Application for a non-material amendment following a grant of planning permission.

Reference number:	<input type="text" value="20/00750"/>
Date of decision	<input type="text" value="04/12/2020"/>

- ALTERATIONS TO GLAZING TO THE PROPOSED GROUND FLOOR EXTENSION
- ONE NEW STRUCTURAL OPENING WITHIN THE PROPOSED GROUND FLOOR EXTENSION
- CHANGE TO ROOF OF GARAGE

drawing: **PROPOSED ELEVATIONS - HOUSE**

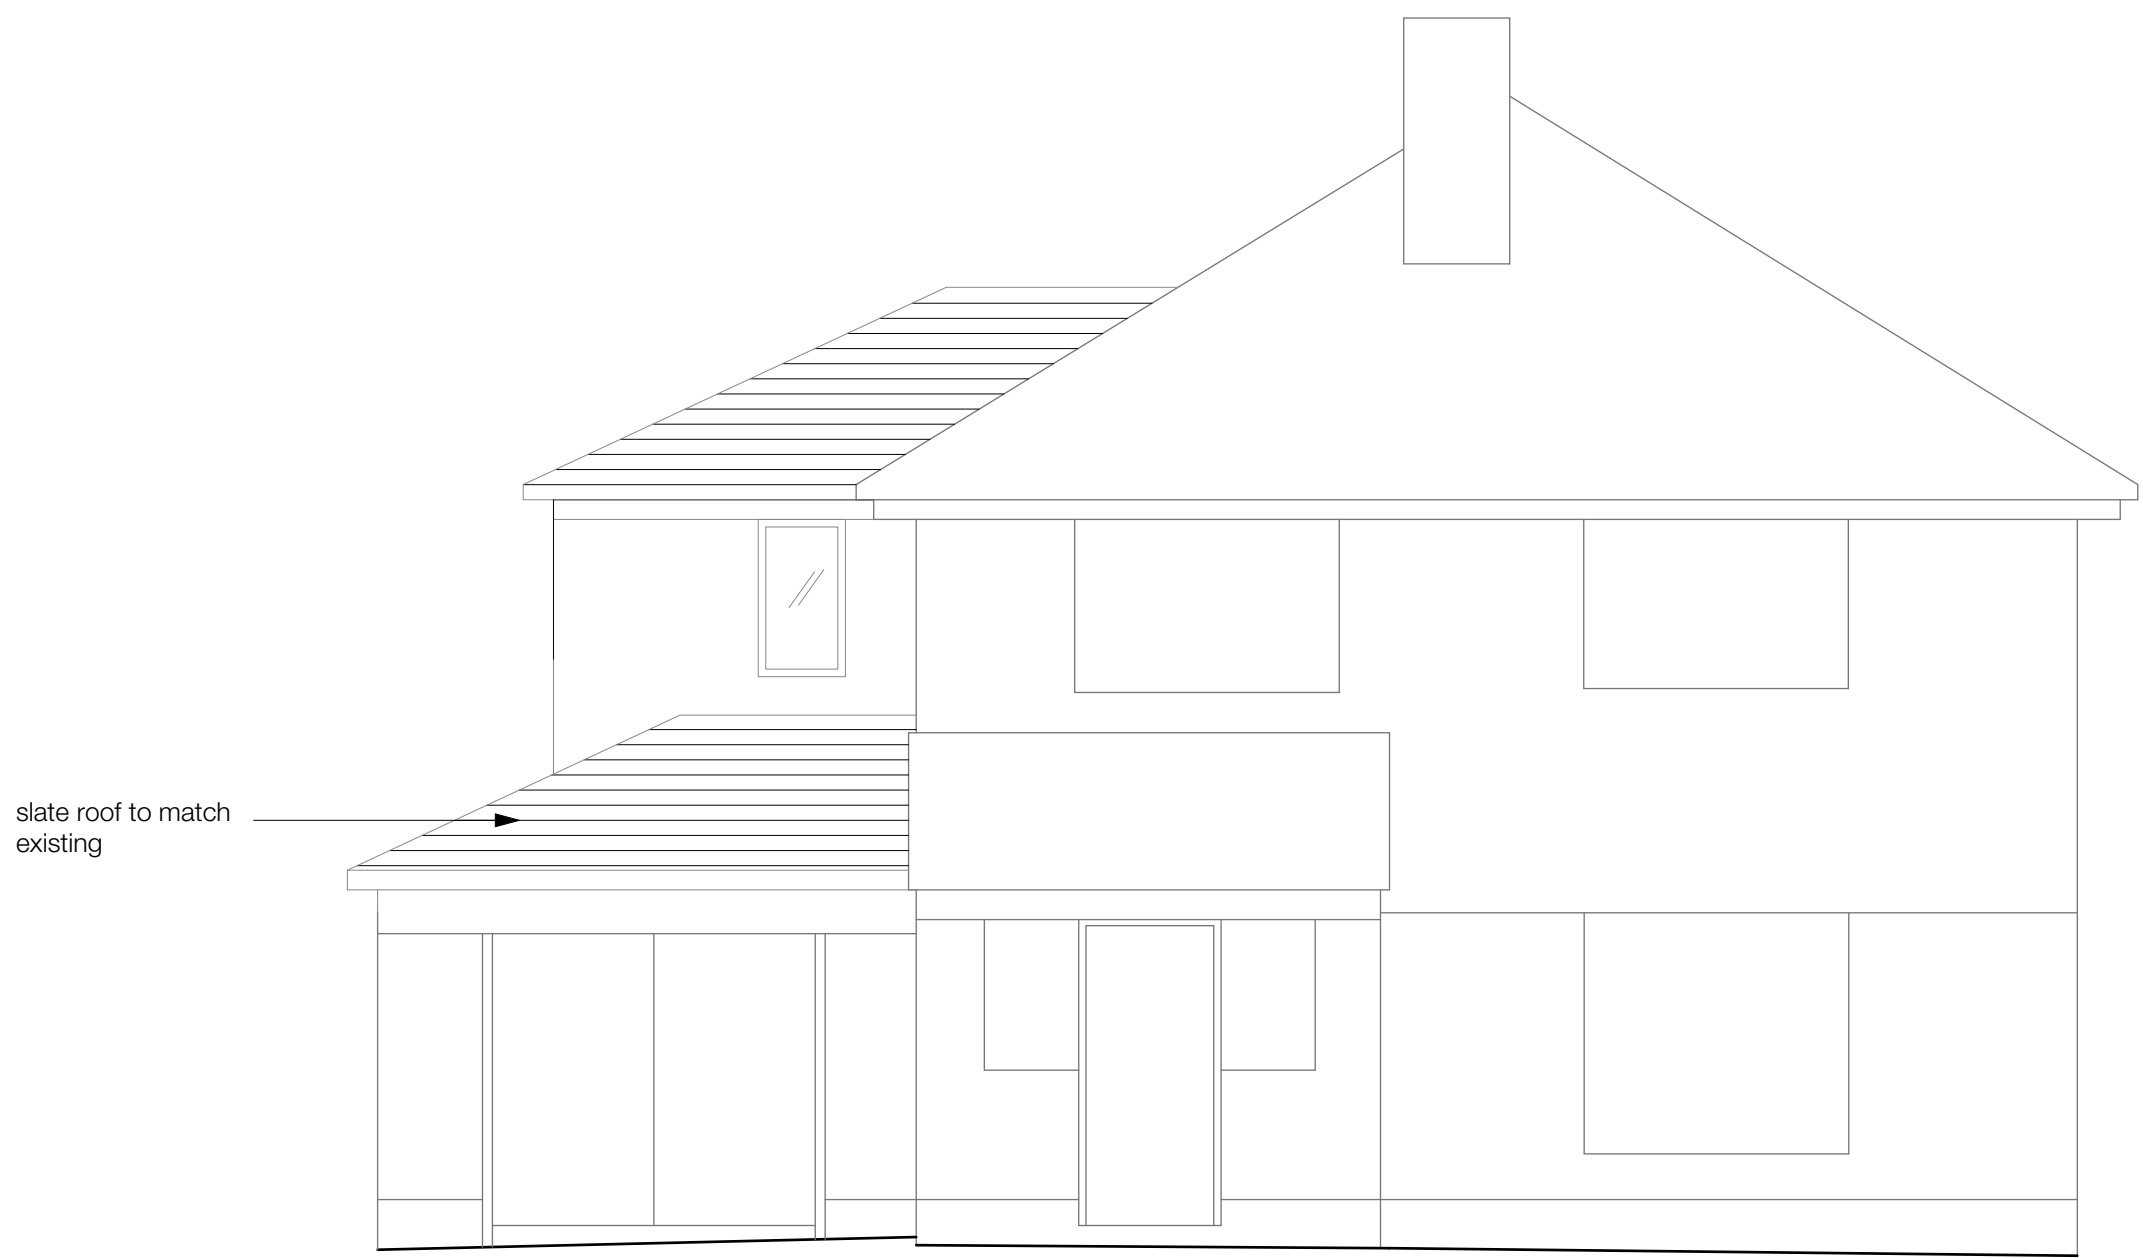
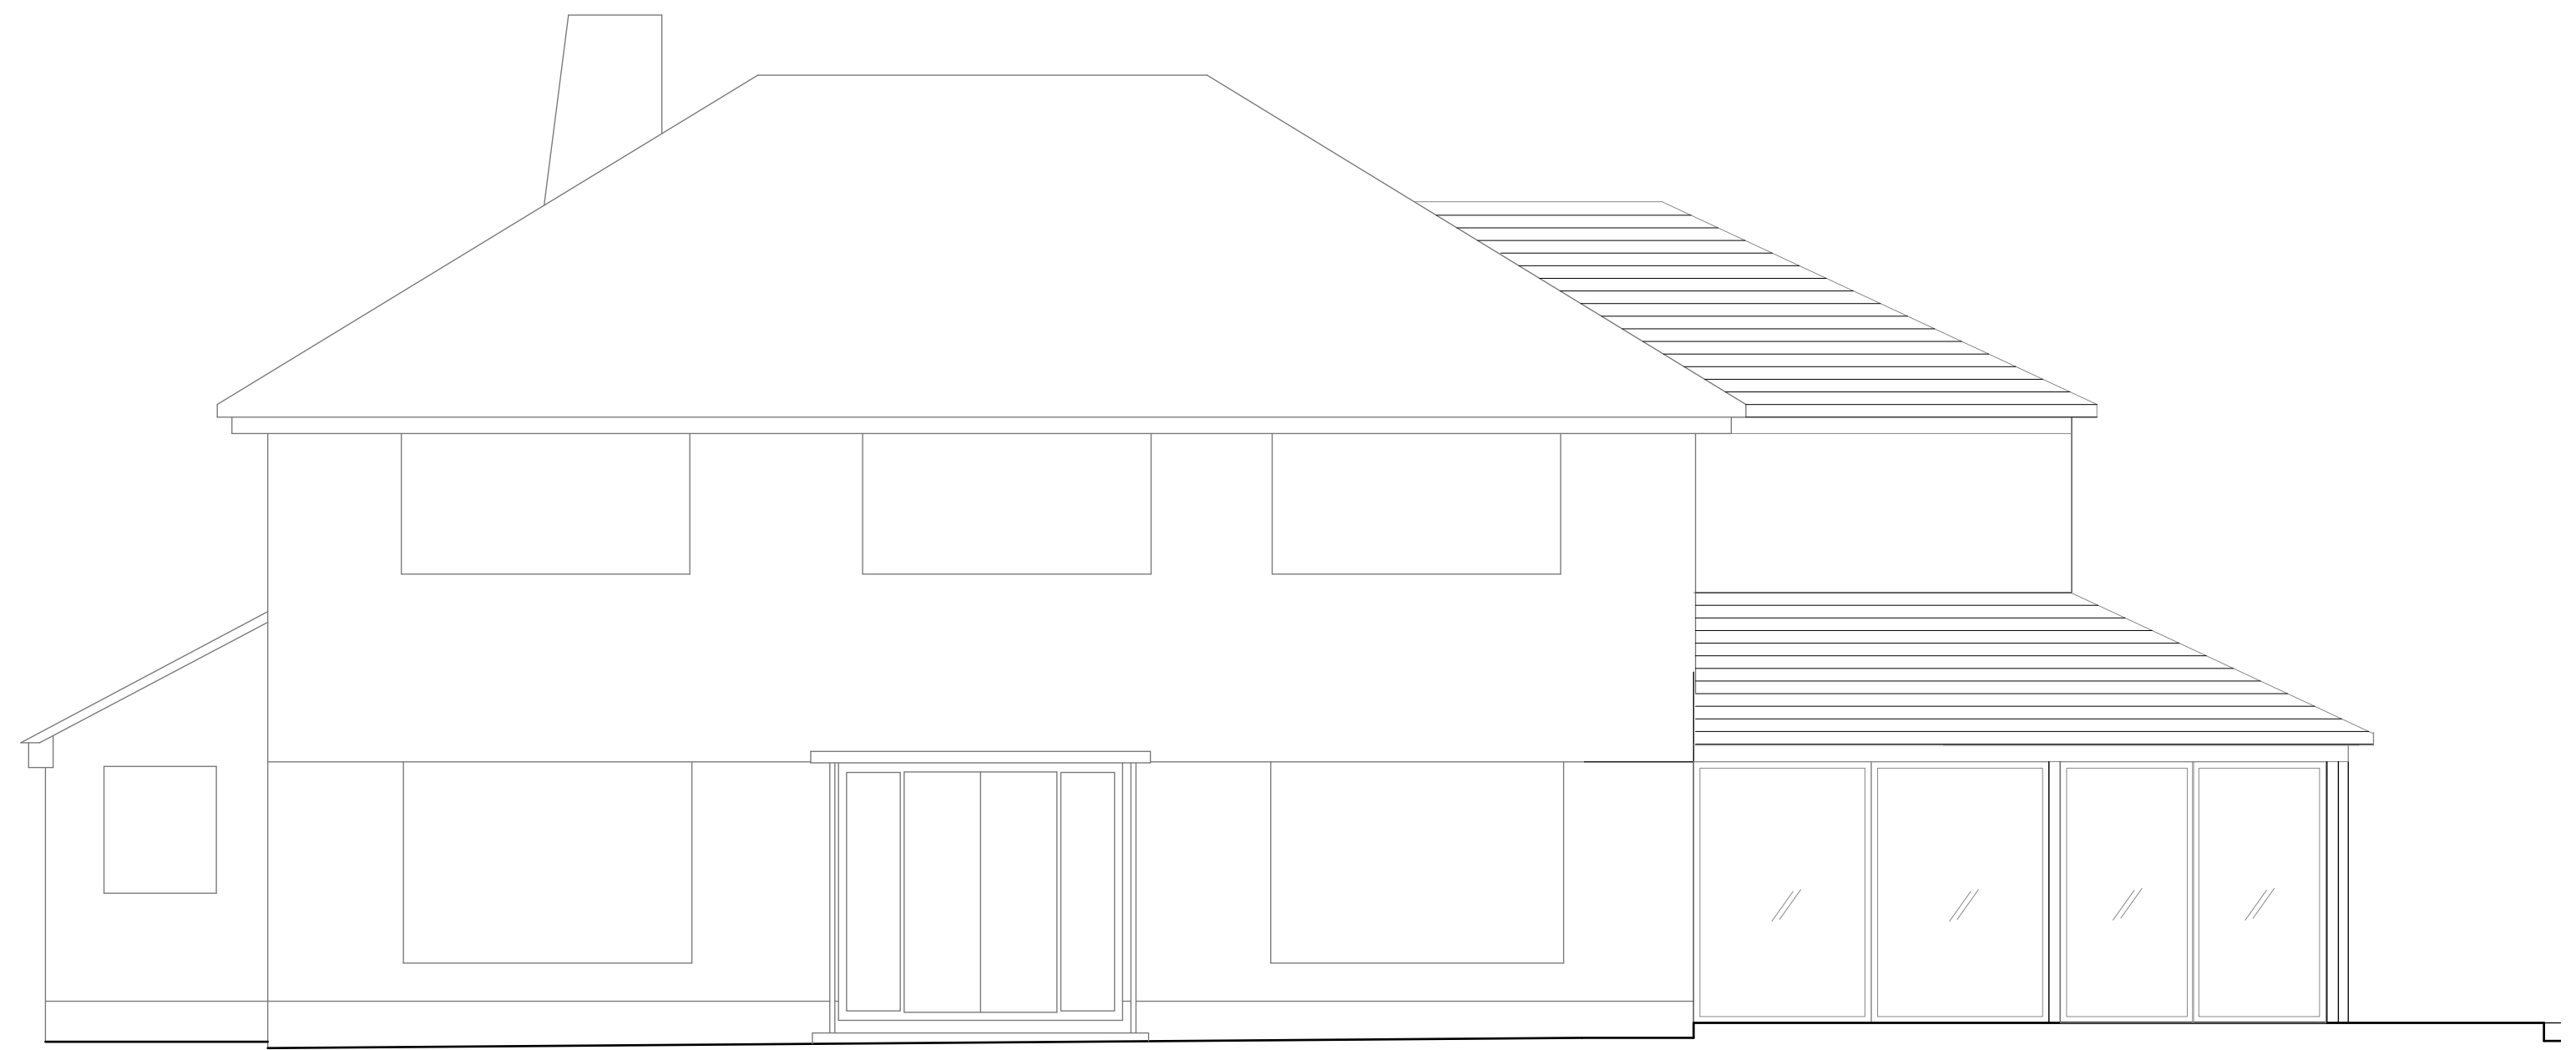
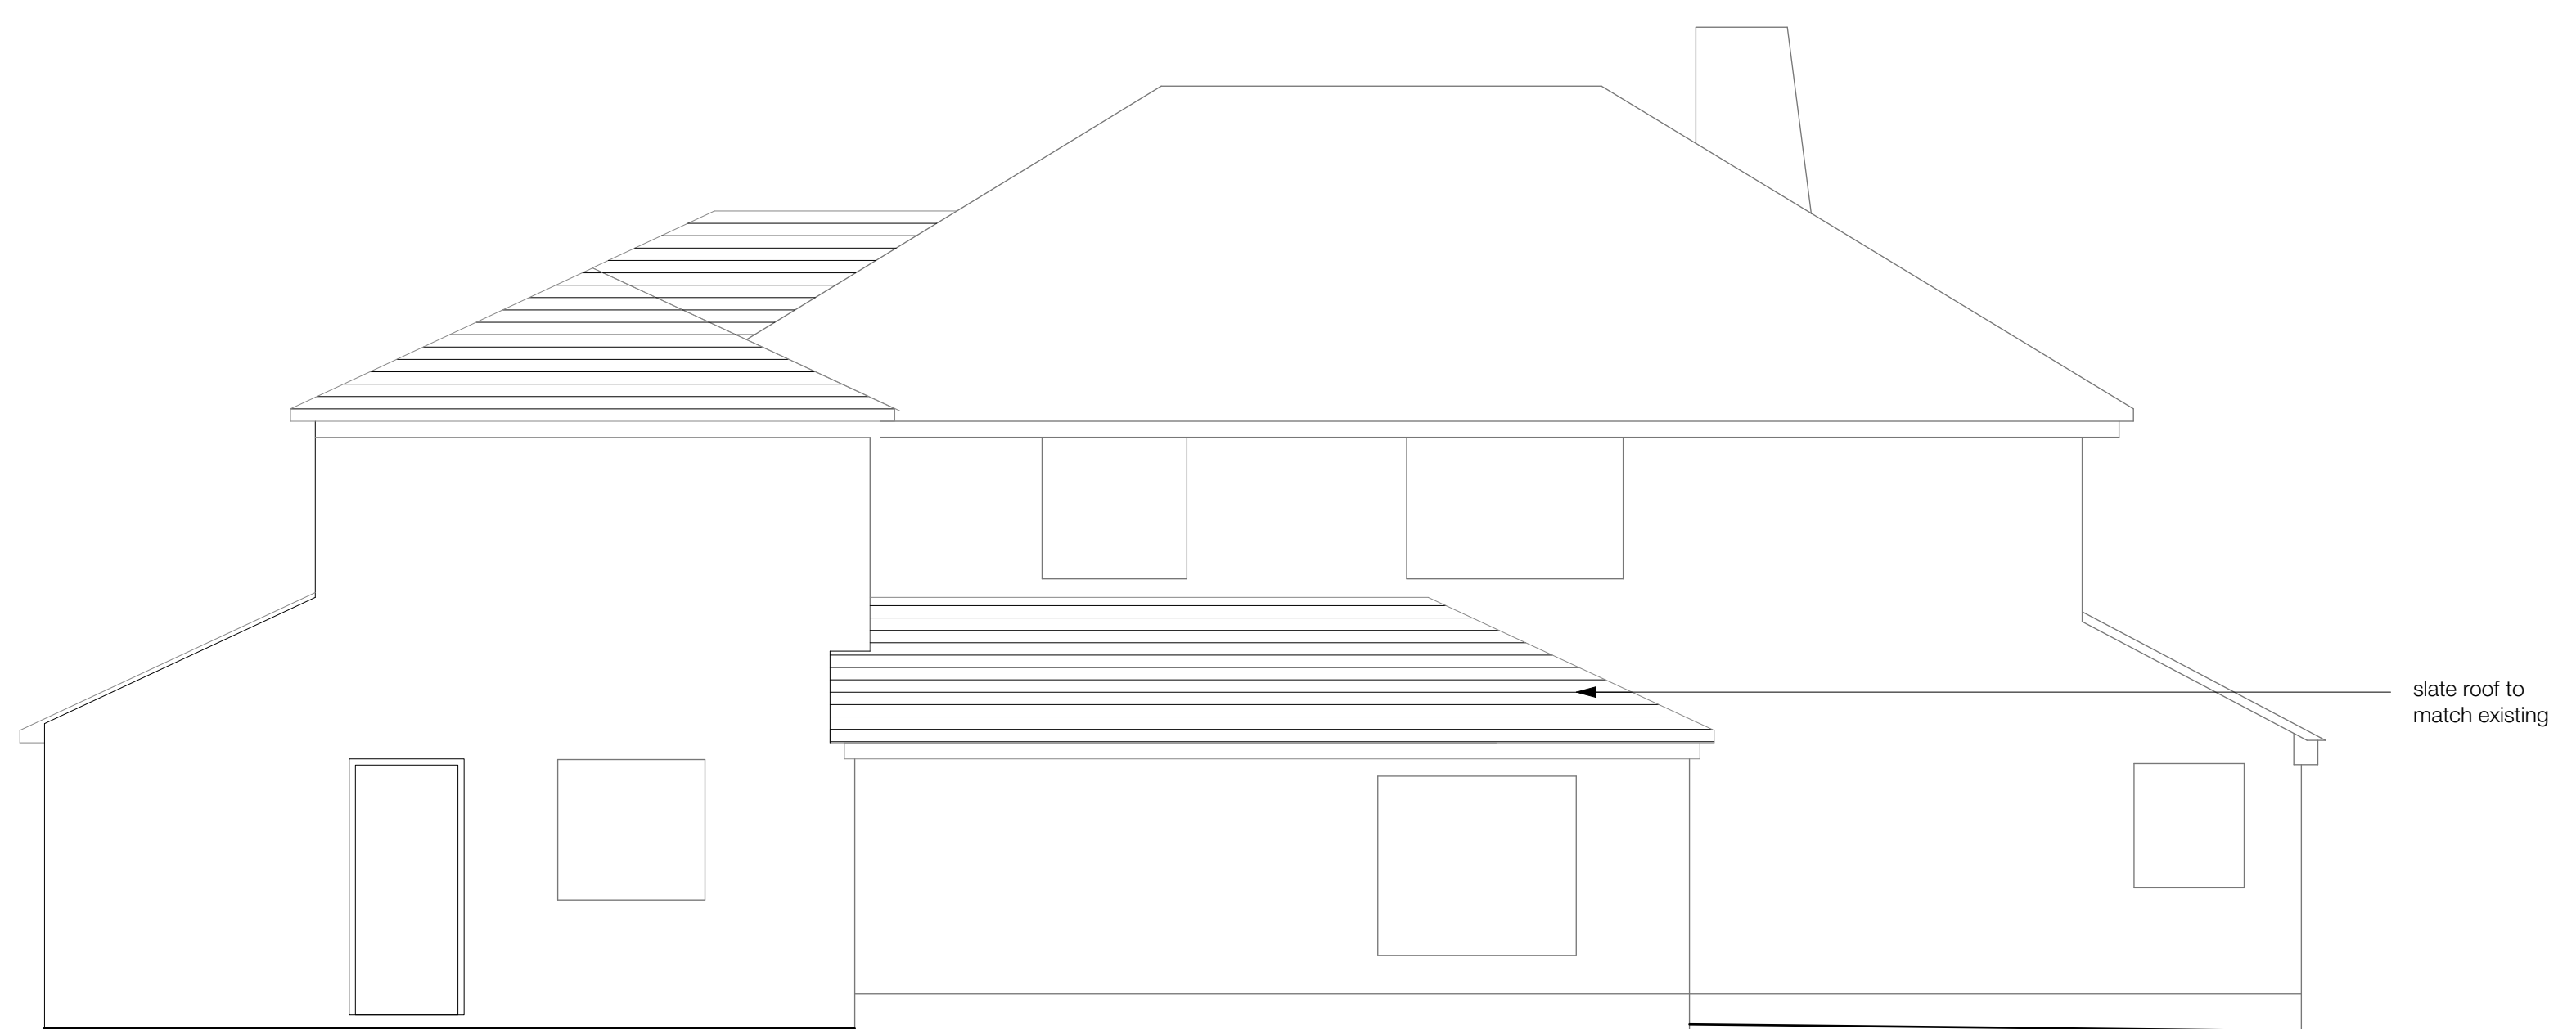
- THE PREVIOUS PROPOSAL DID NOT PROVIDE ENOUGH GLASS AND THEREFORE ENOUGH NATURAL LIGHT TO THE INTERNAL SPACES
- THE GROUND FLOOR LAYOUT HAS BEEN ALTERED SO AN ADDITIONAL STRUCTURAL OPENING WAS REQUIRED
- THE ROOF JUNCTION ABUTTING THE NEW GARAGE ROOF WITH THE EXISTING BUILDING WITHIN THE PREVIOUS DESIGN DID NOT WORK
